Our Case Number: ABP-318505-23

Re: Proposed construction of a 110kV underground grid connection cable connecting the permitted Carrownagowan windfarm to the existing 110kV substation at Ardnacrusha.
Within the townlands of Caherhurly, Killokennedy, Cloongaheen West, Leitrim, Castlebank, Ballykeelaun, County Clare. (www.carrownagowangridplanning.ie)

19th January 2024

Submission of the Planning Authority regarding application ABP-318505-23 made under Section 182A(1) of the Planning and Development Act, 2000 (as amended)

Ducting Through Roadways

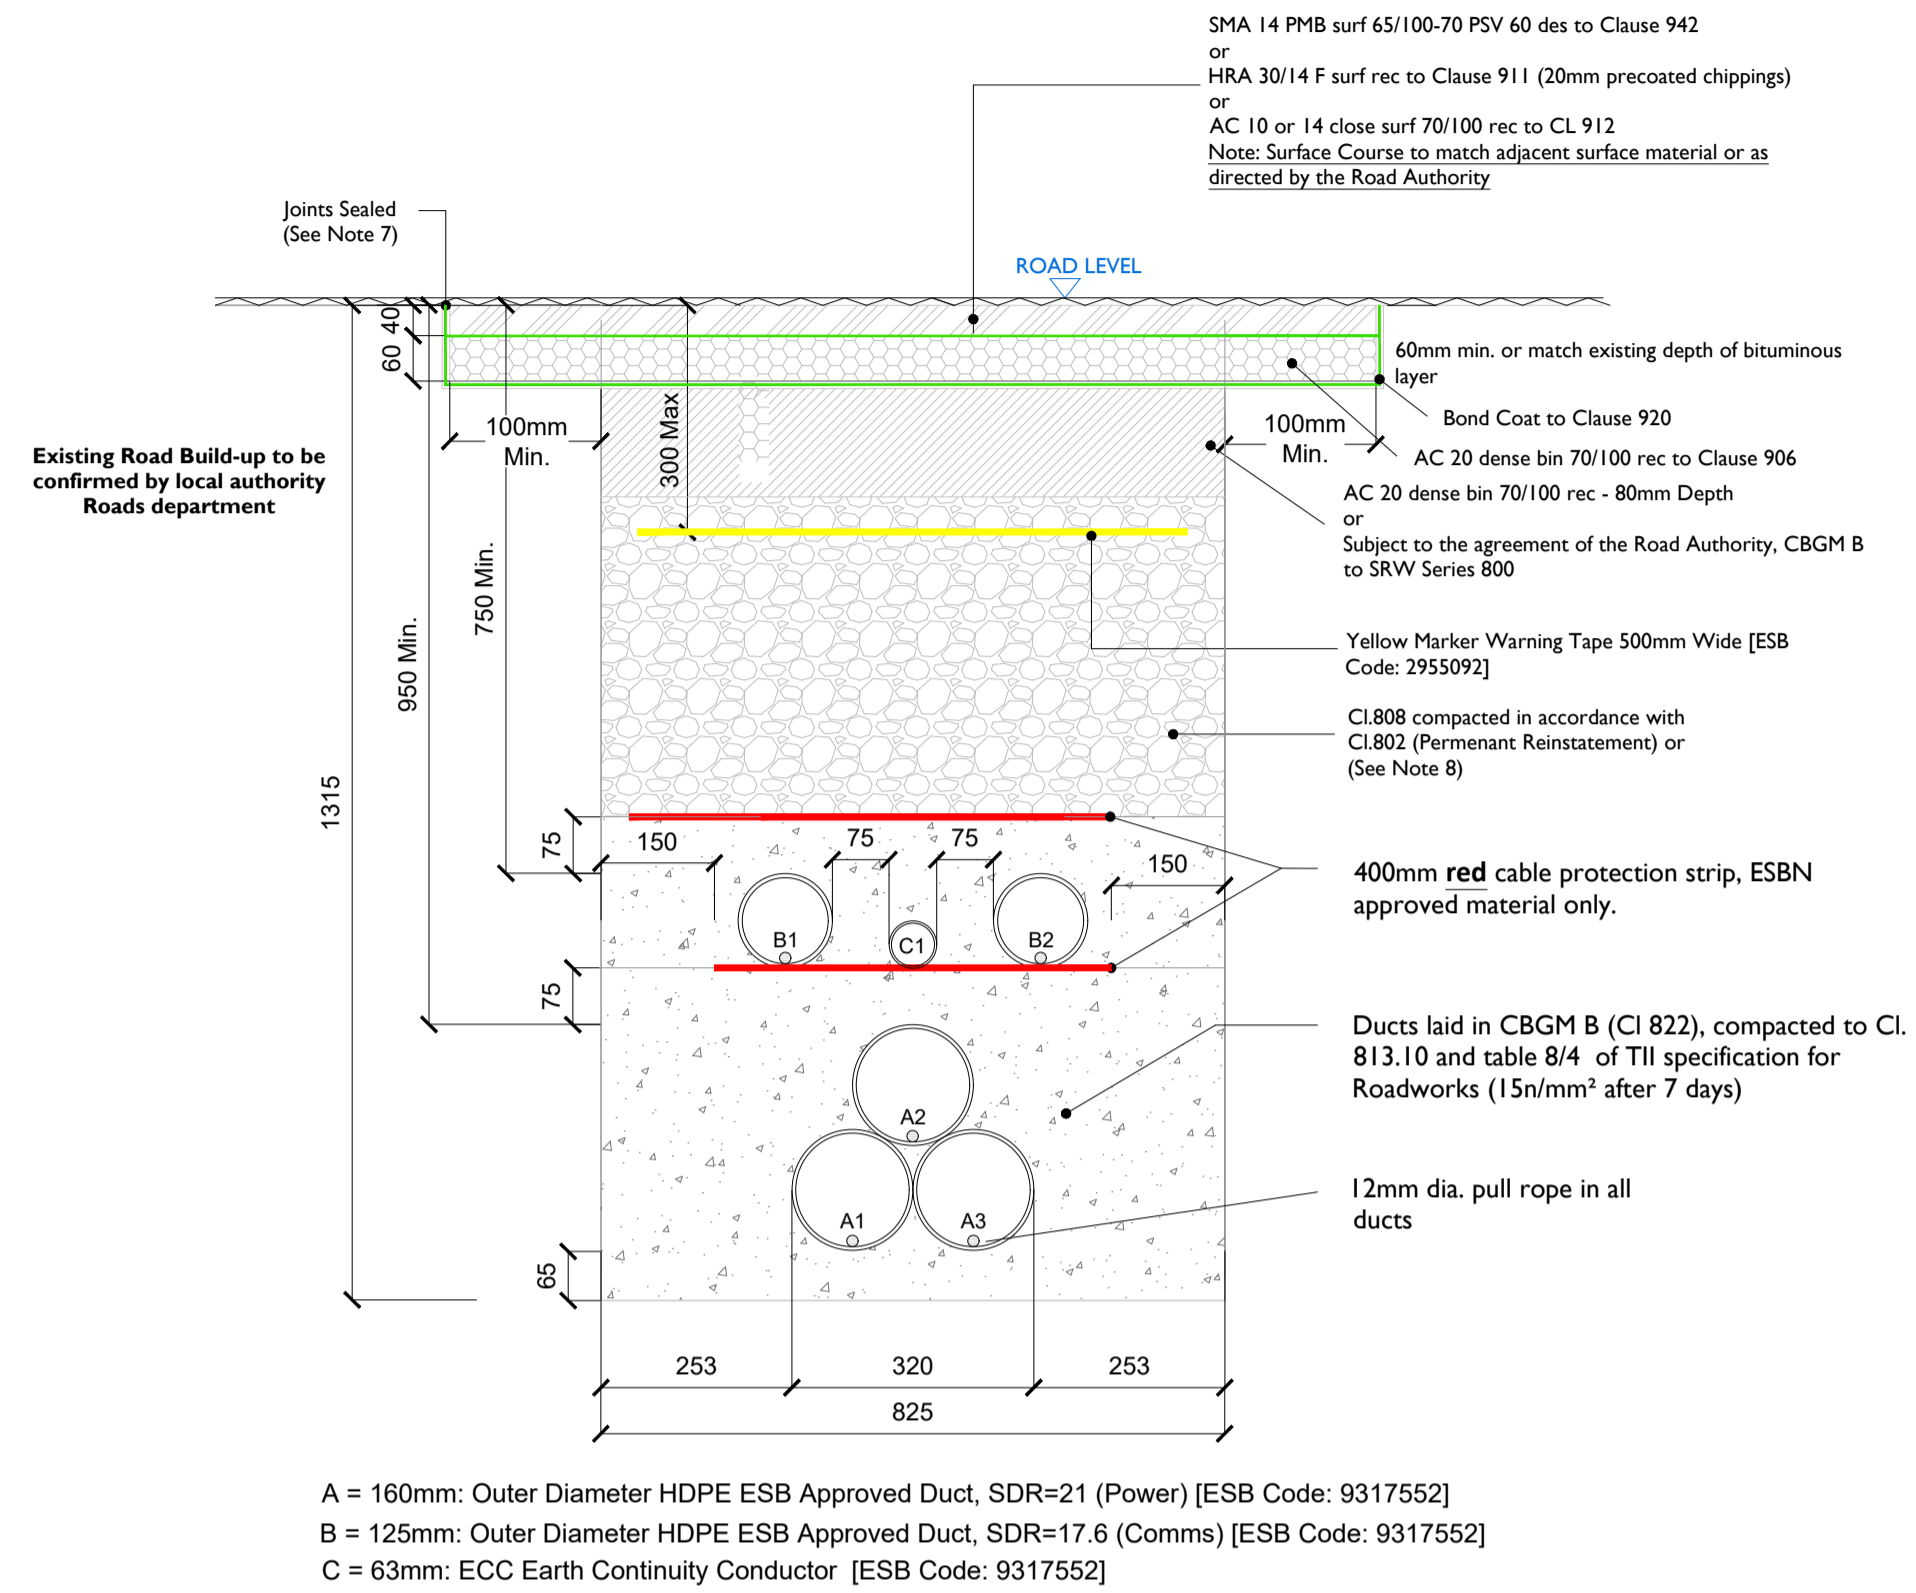
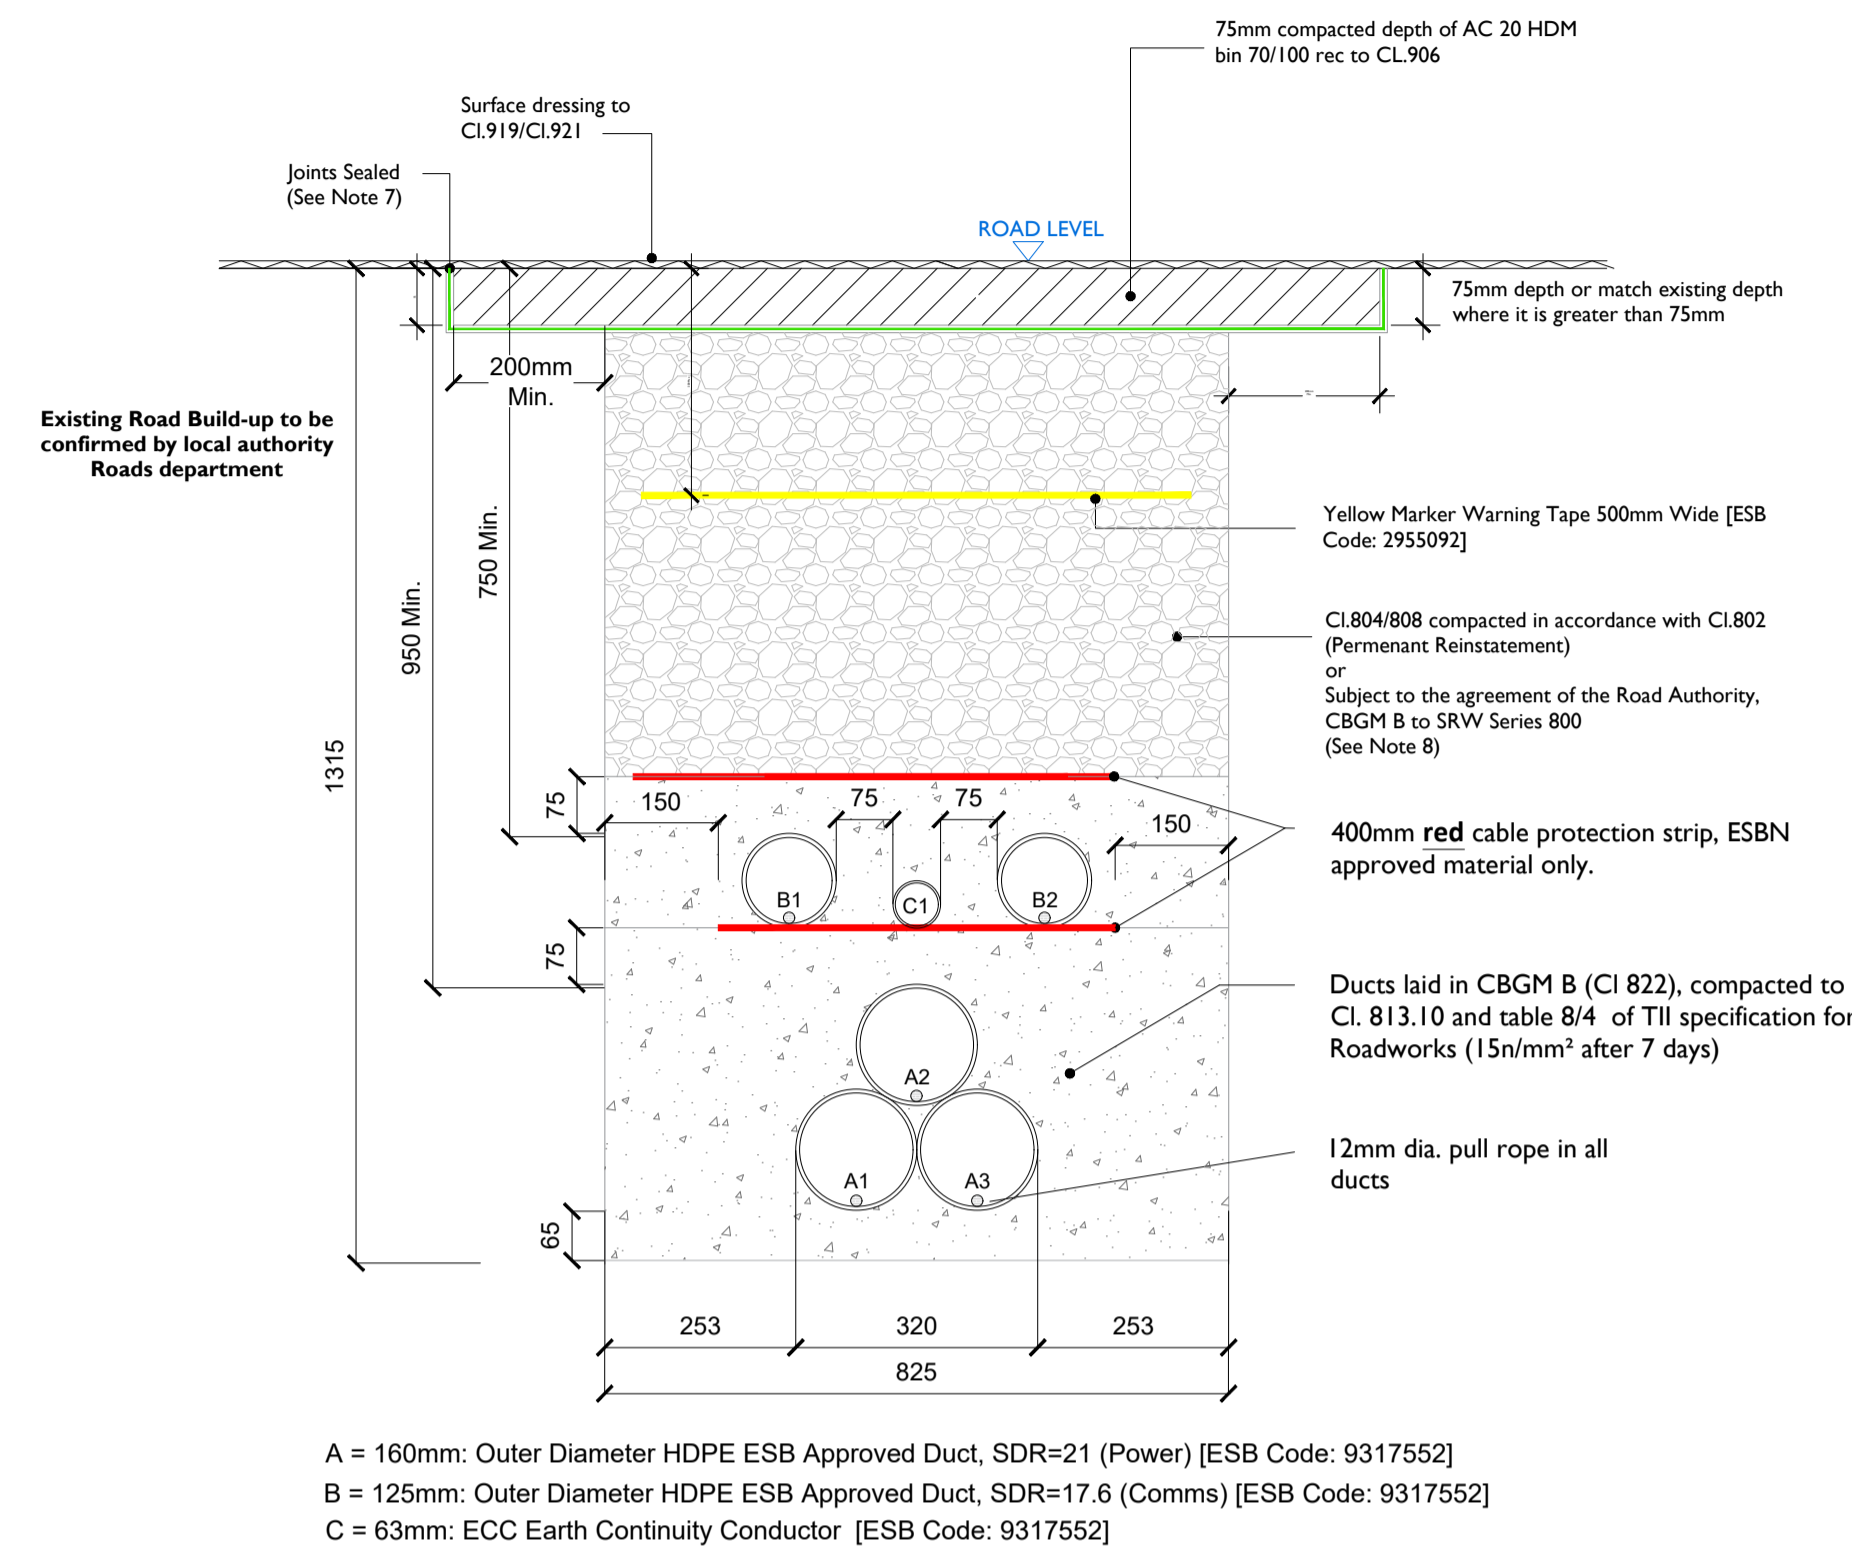
- Lane width reinstatement will be required on the R-466 Regional Roads in compliance with Standard Drawing SD4 of the Guidelines for Managing Opening in Public Roads, Second Edition (Rev 1) April 2017.
- Full road width reinstatement will be required on the R-471 Regional Roads in compliance with Standard Drawing SD4 of the Guidelines for Managing Opening in Public Roads, Second Edition (Rev 1) April 2017.

- All junctions with opening and changes in direction of routes at junctions will require full junction reinstatement in compliance with Standard Drawing SD4 of the Guidelines for Managing Opening in Public Roads, Second Edition (Rev 1) April 2017.

- Launch and received pits from directional drilling must be reinstated in compliance with Standard Drawing SD4 of the Guidelines for Managing Opening in Public Roads, Second Edition (Rev 1) April 2017.

- Lane width reinstatement will be required from Ch0m to Ch2700m in compliance with Standard Drawing SD4 of the Guidelines for Managing Opening in Public Roads, Second Edition (Rev 1) April 2017.

- Local roads shall receive double surface dressing on 100mm paved Cl.806 full road reinstatement, Surface dressing to be carried out by an approved contractor, works to be completed within the surface dressing season in compliance with Standard Drawing SD5 of the Guidelines for Managing Opening in Public Roads, Second Edition (Rev 1) April 2017 and in compliance with the IAT Guidelines for Surface Dressing.

- Sections of road in marsh/peat areas shall be overlaid in 150mm depth capping to Cl6F2, Securgrid or similar approved, 100mm depth of Cl.804 and double surface dressing or otherwise similarly approved by the Killaloe or Shannon Municipal District.

Trench Sections For Undercrossing
 Existing Culverts / Services

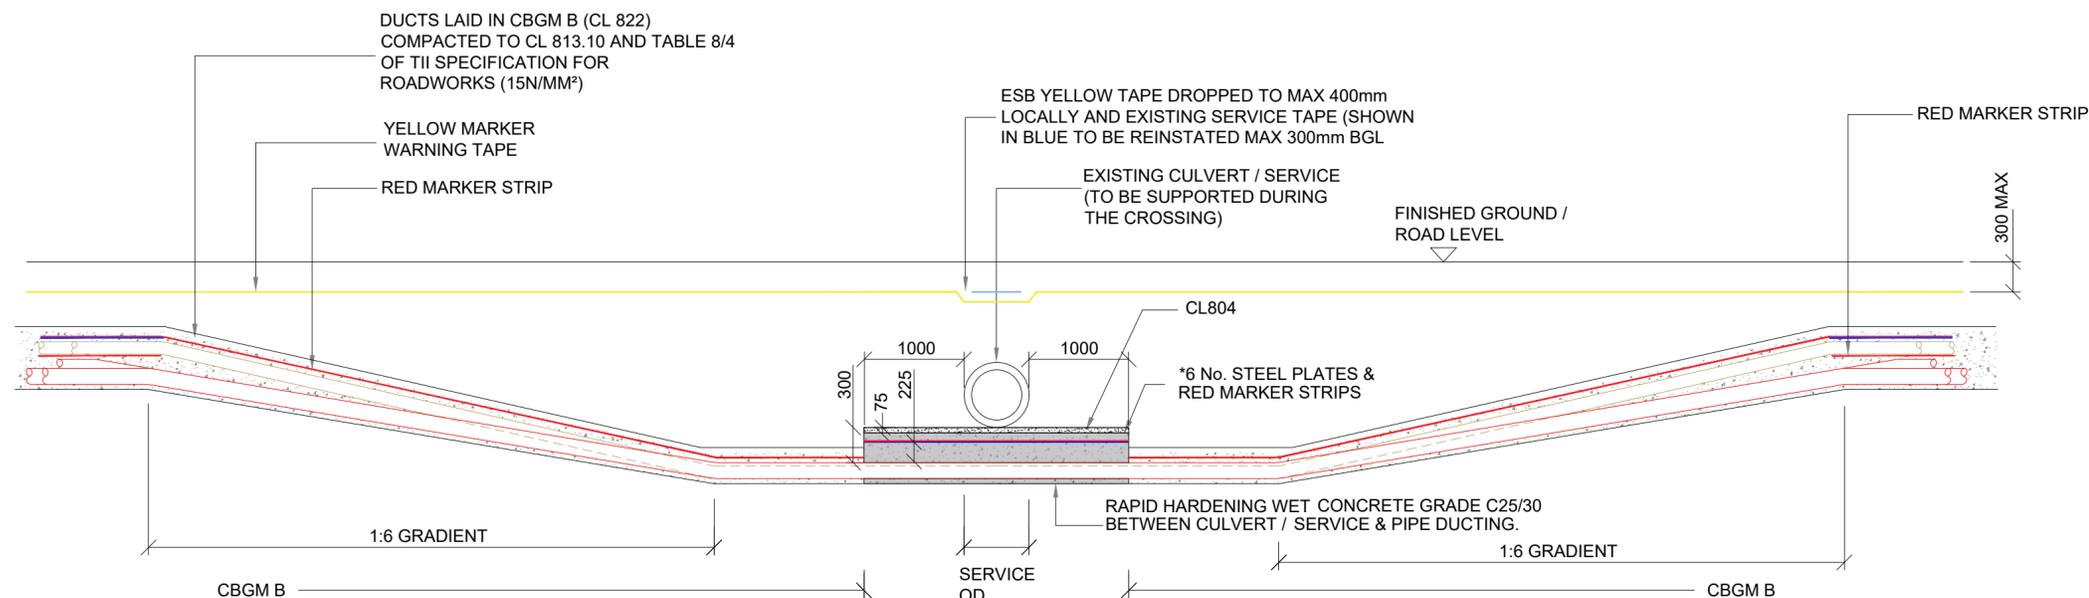
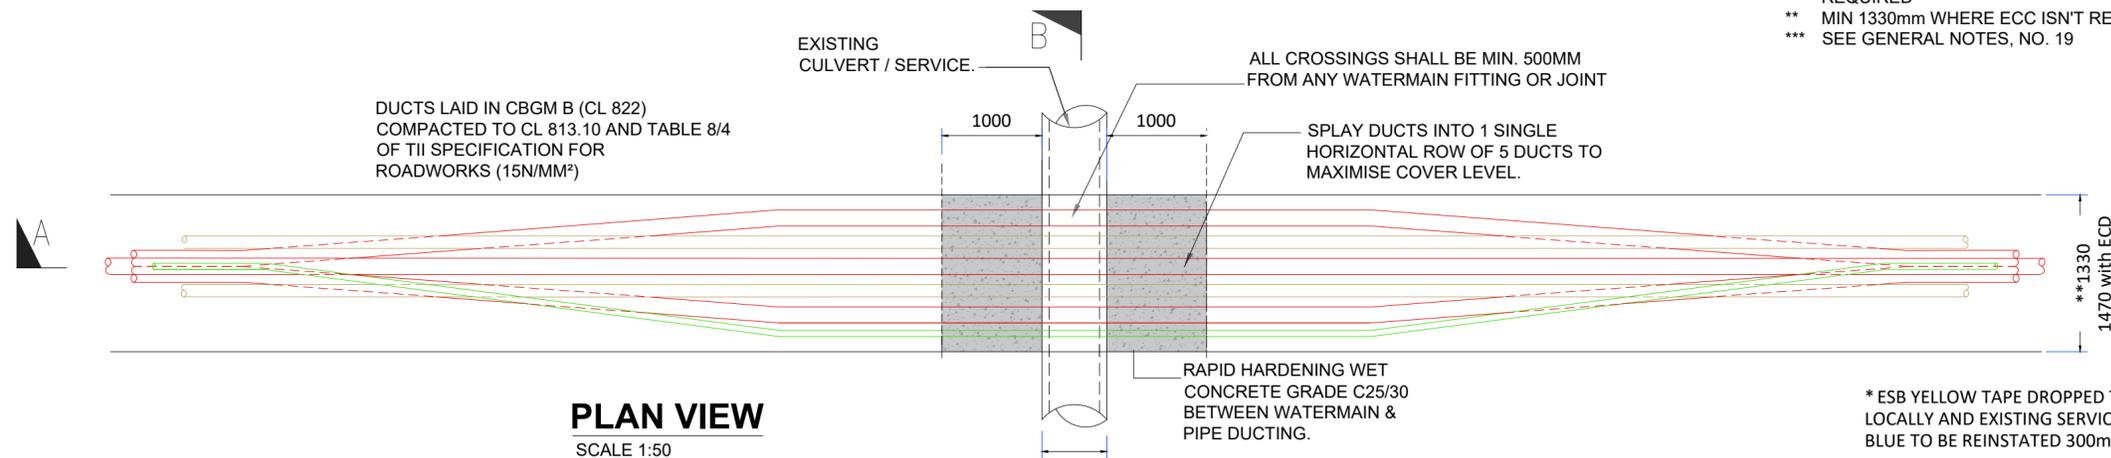
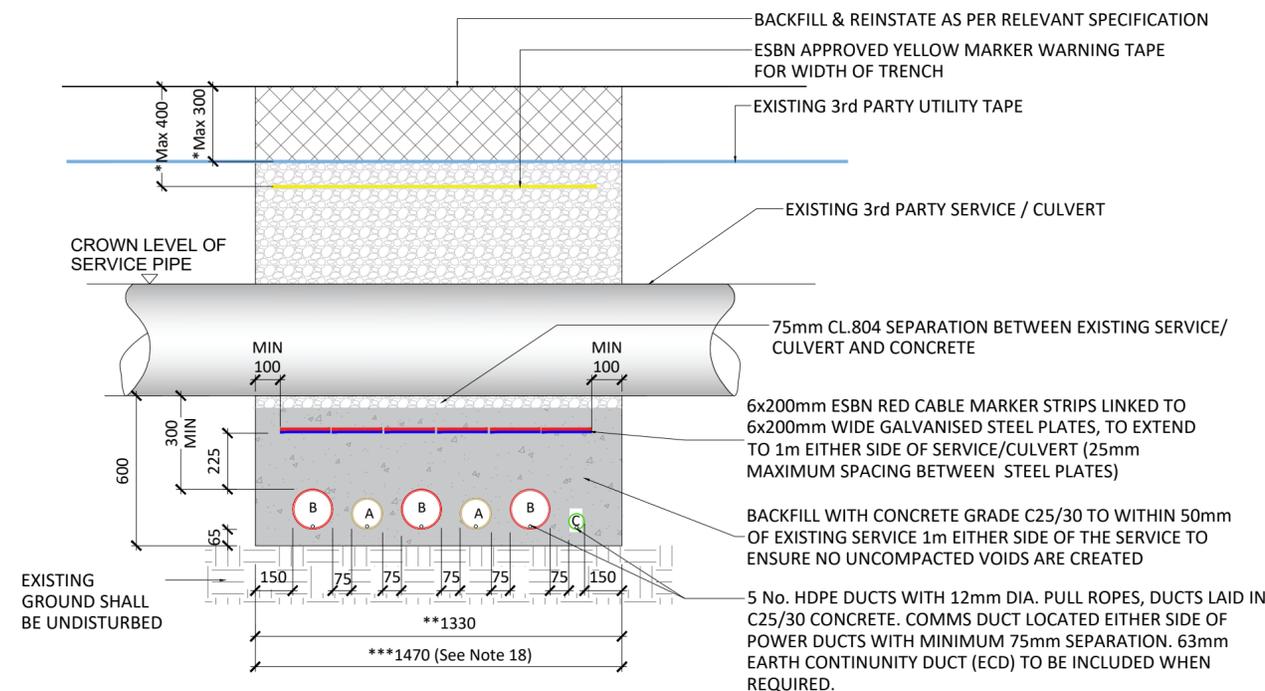
- A pre-condition survey must be carried out on all bridges/culverts and pipelines along the grid route.
- Damage to any structure will require immediate notification to the Scariff or Shannon Offices of Clare County Council. Full replacement of damaged structures and pipelines will be required.
- Post works surveys of each Bridge/Culvert structures will be required.
